From: Joe Russell-Wells
Sent: 14 December 2012 15:30
To: Neil Crowther
Subject: FP/155/12/DOC - Conditions 10, 11 and 19

Condition 10

Condition 11

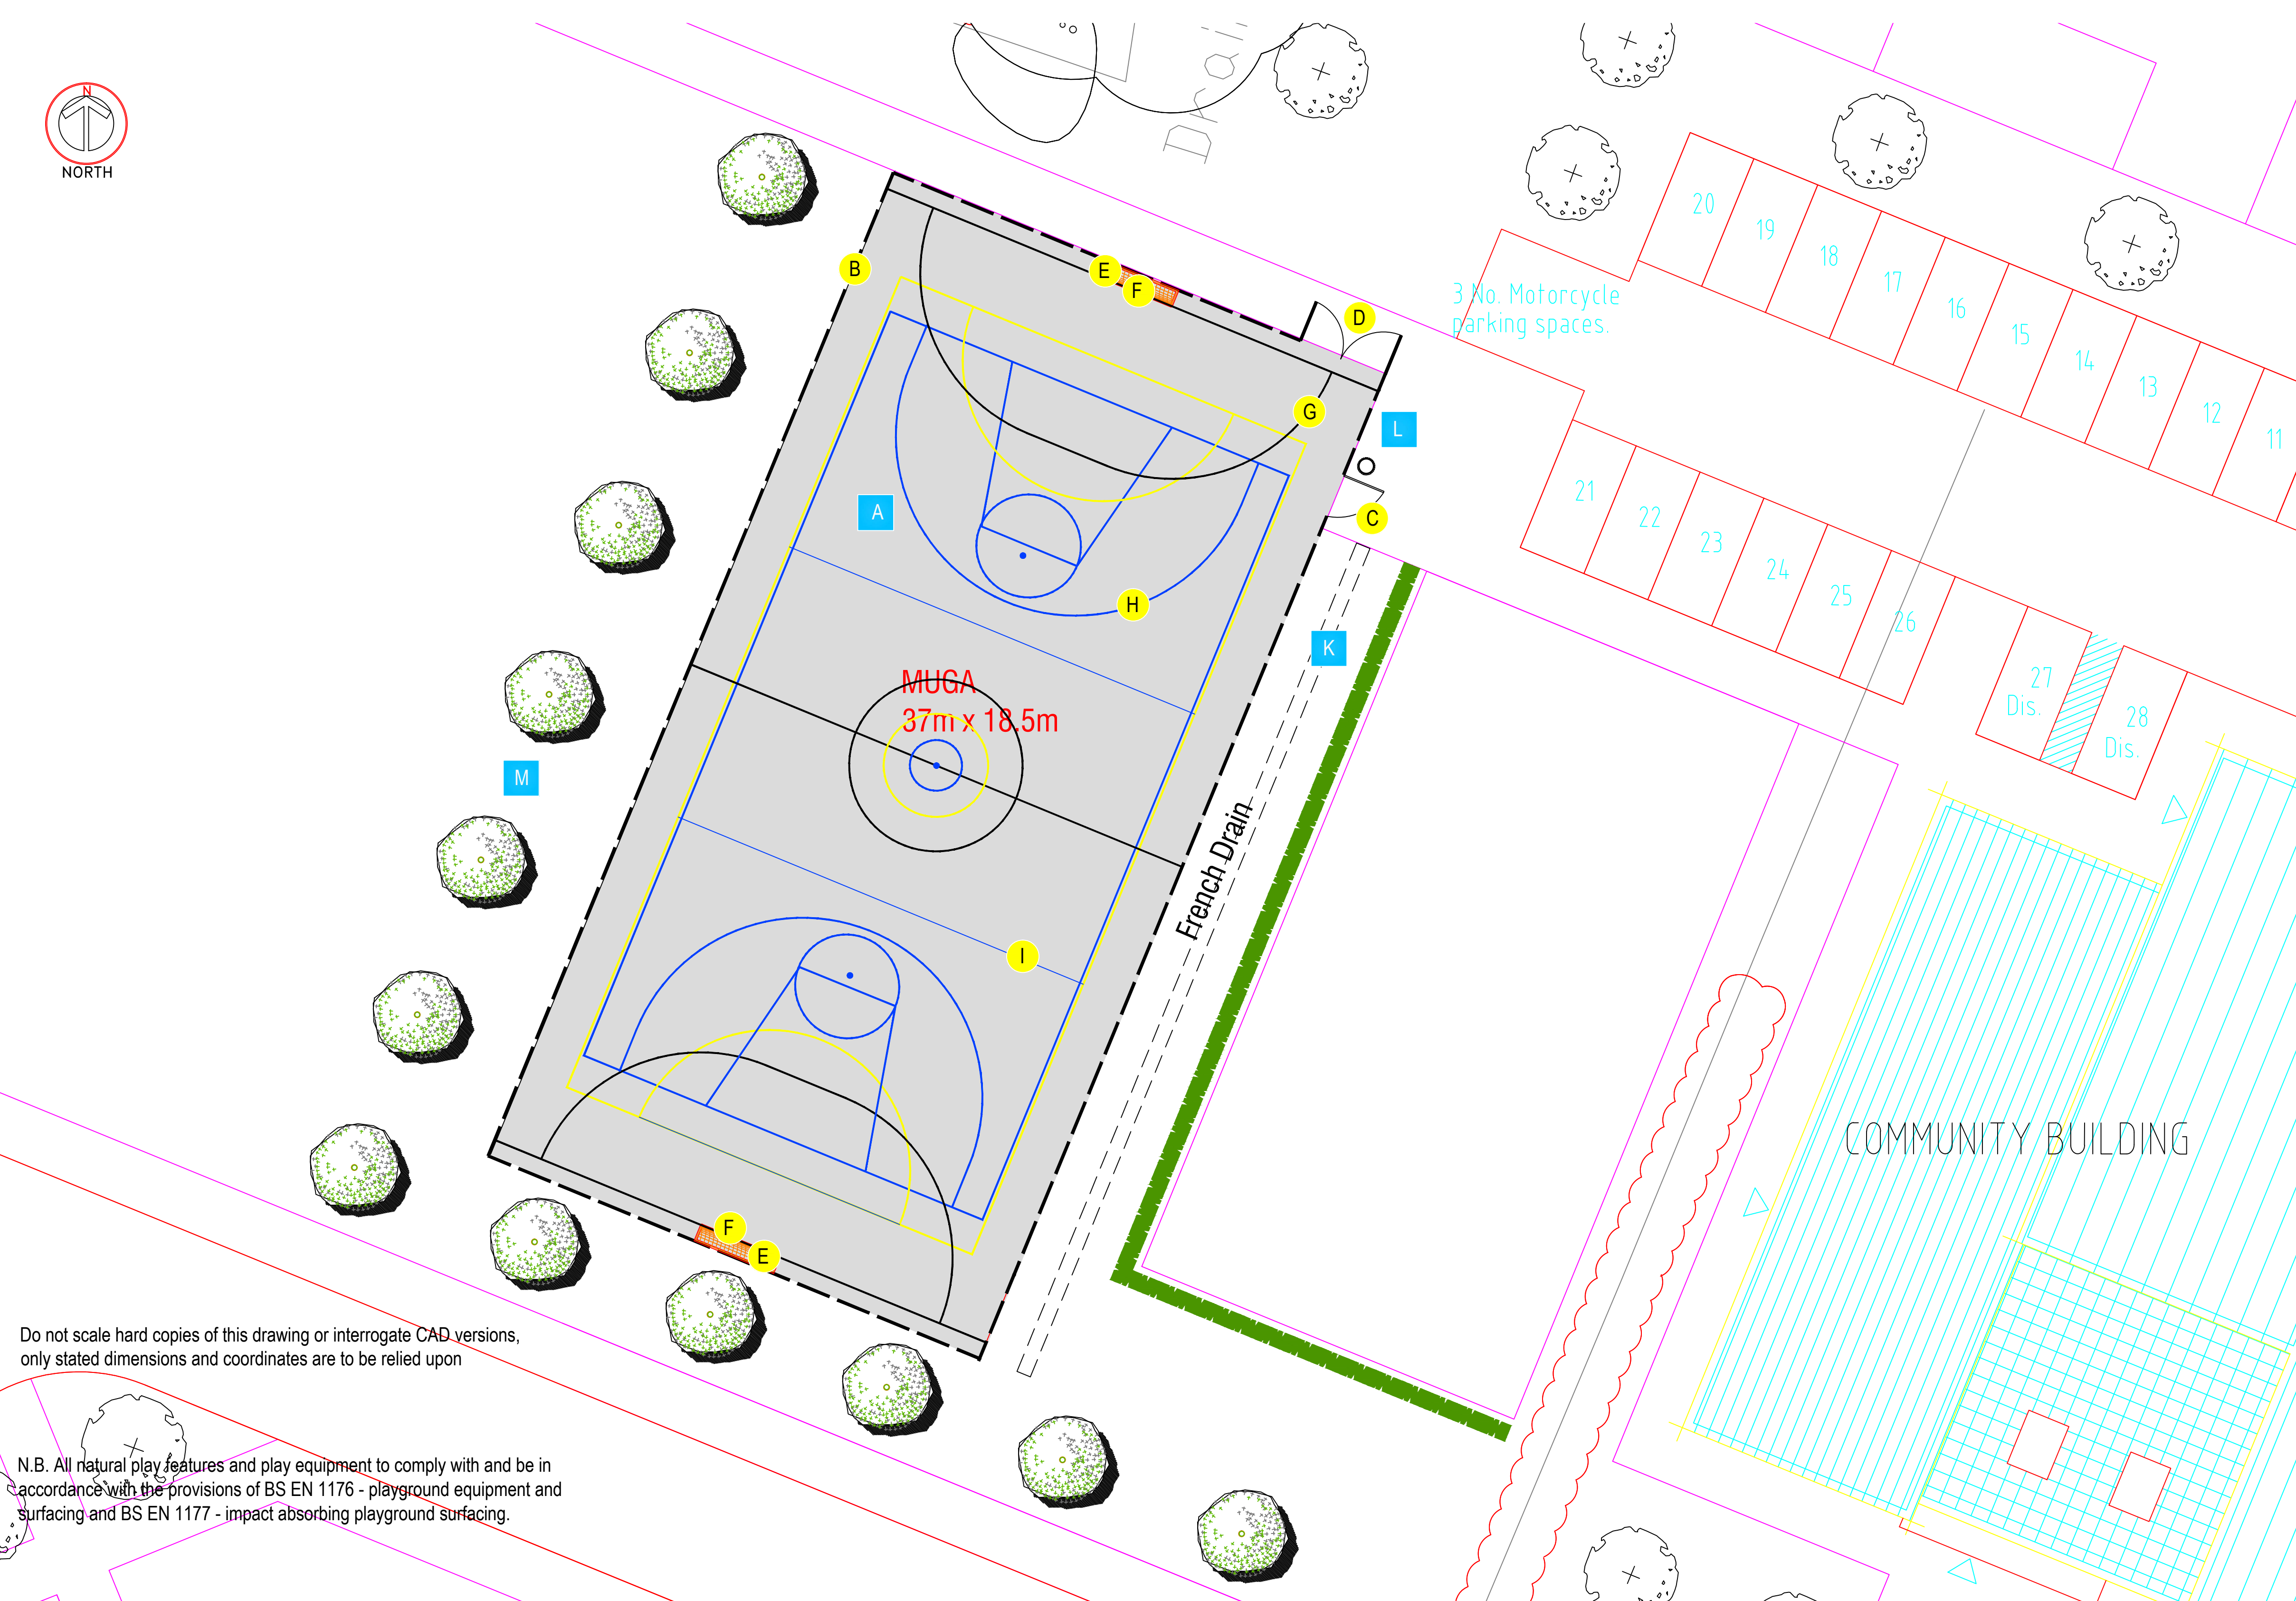
- Please provide spec for Breedon gravel path
- Both bins L replace with ADC spec and omit 'Orchard' bins
- Provide detail on Western mound - looks like two planks of wood?
- Provide additional seating 2 no
- Because maintenance gate is likely to be used as main access this must be combined with a pedestrian self-closing access gate
- The detail of the landscaping indicated as integral to the play area needs to be provided – this does not form part of previously approved plans.

MUGA
37m x 18.5m

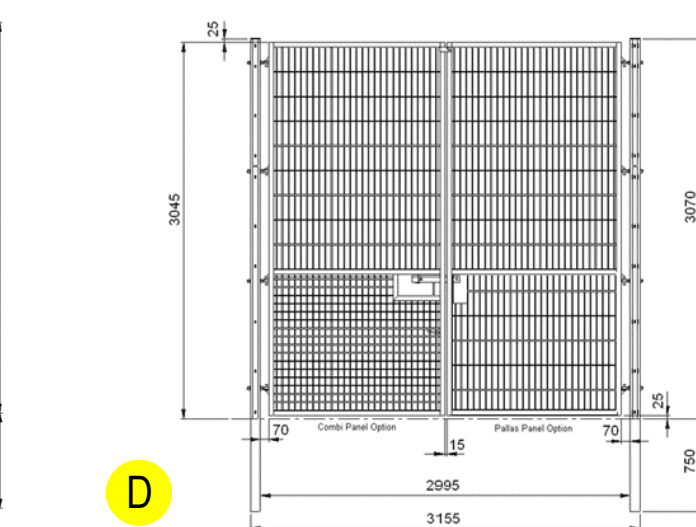
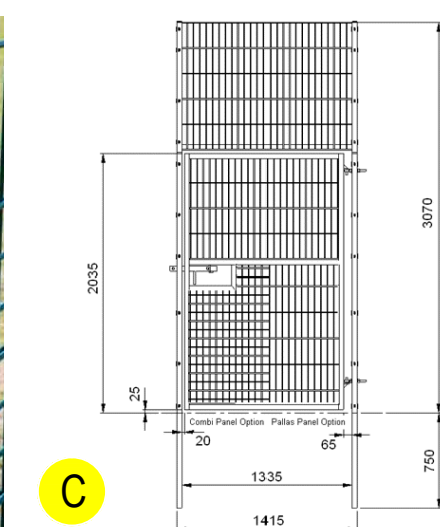
- Please provide further specification on fencing and sample of materials. Its suitability of use within a public space needs to be clarified prior to any approval

- Please provide a construction detail on the surfacing of the tarmac area to ensure adequacy
- Please provide detail including any soak away for French Drain adjacent to the MUGA
- The design of the football and basketball combination does not appear to work – the location of the basketball hoops would be set too far back from court. This must be addressed in a revised plan.

MUGA – the space does not need to be provided to competition standard, but does need to use the space available. The details of the specification for construction does need to be provided for approval. The facility will be used for football and basketball.

SKATE PARK, Blakes Mead - Felpham

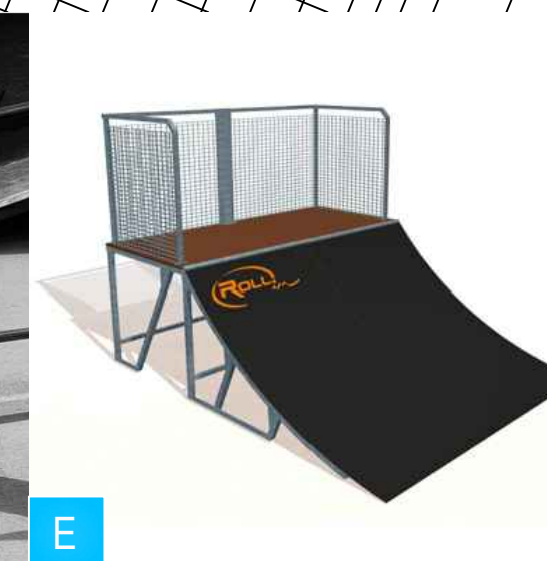
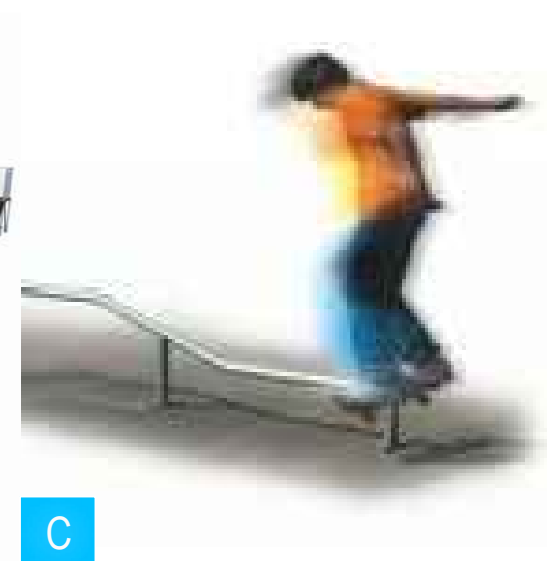
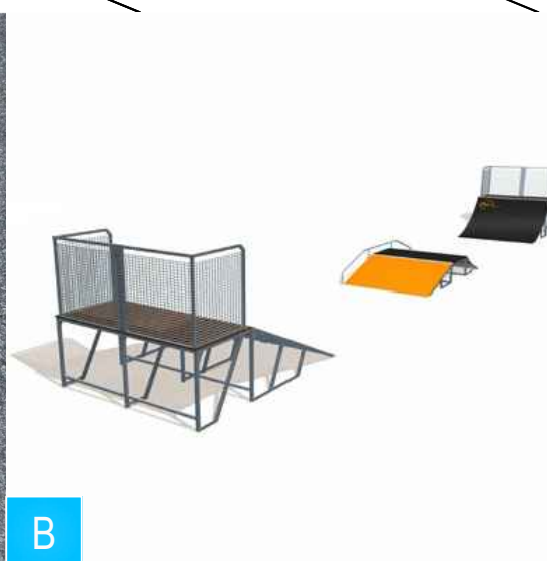
- Ramp style must be boxed in and not open to enable access beneath the ramps
- A specification of the materials to be used should be provided in order to ensure they are suitable for a public park
- The detail of the landscaping indicated as integral to the play area needs to be provided – this does not form part of previously approved plans.

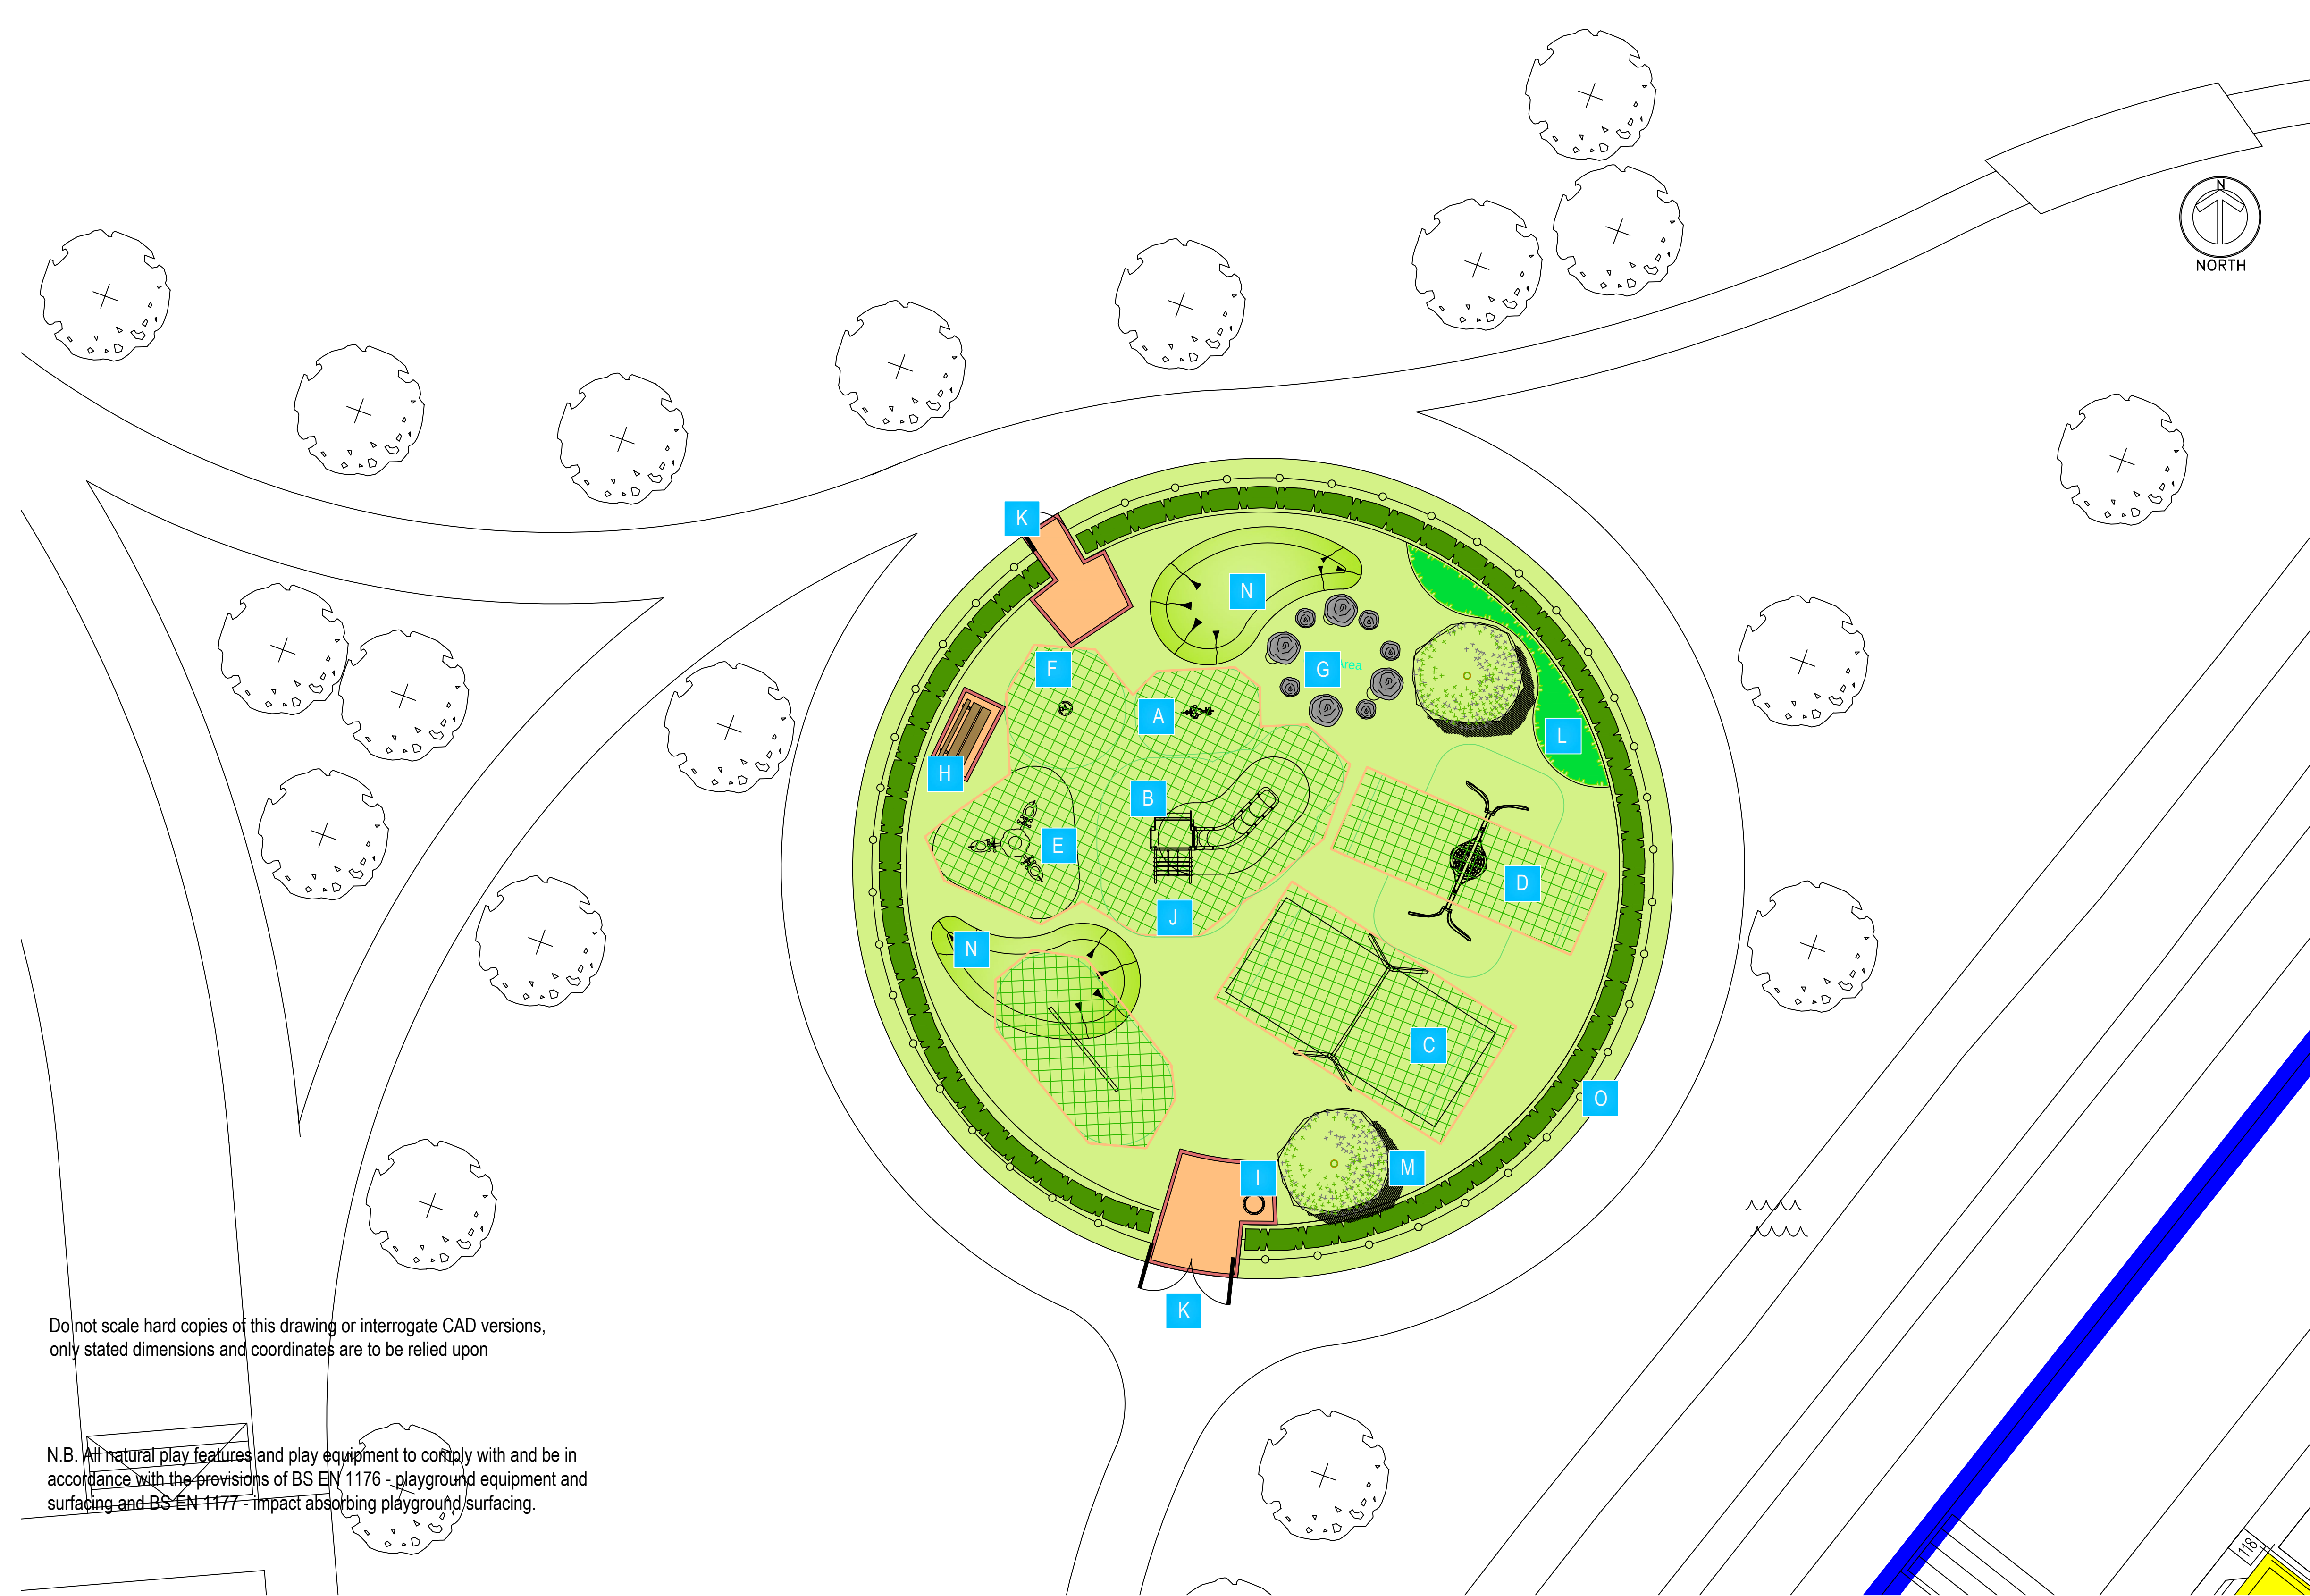
- Specify colour of bow top fencing – note powder coated but no colour specified
- One item not labelled - balance beam? Mound overlays this item – further clarification needed
- J - please specify type of rubber matting and fixing arrangement
- I - litter bin as per ADC specification needs to be included – omit 'Orchard' bin
- The detail of the landscaping indicated as integral to the play area needs to be provided – this does not form part of previously approved plans.
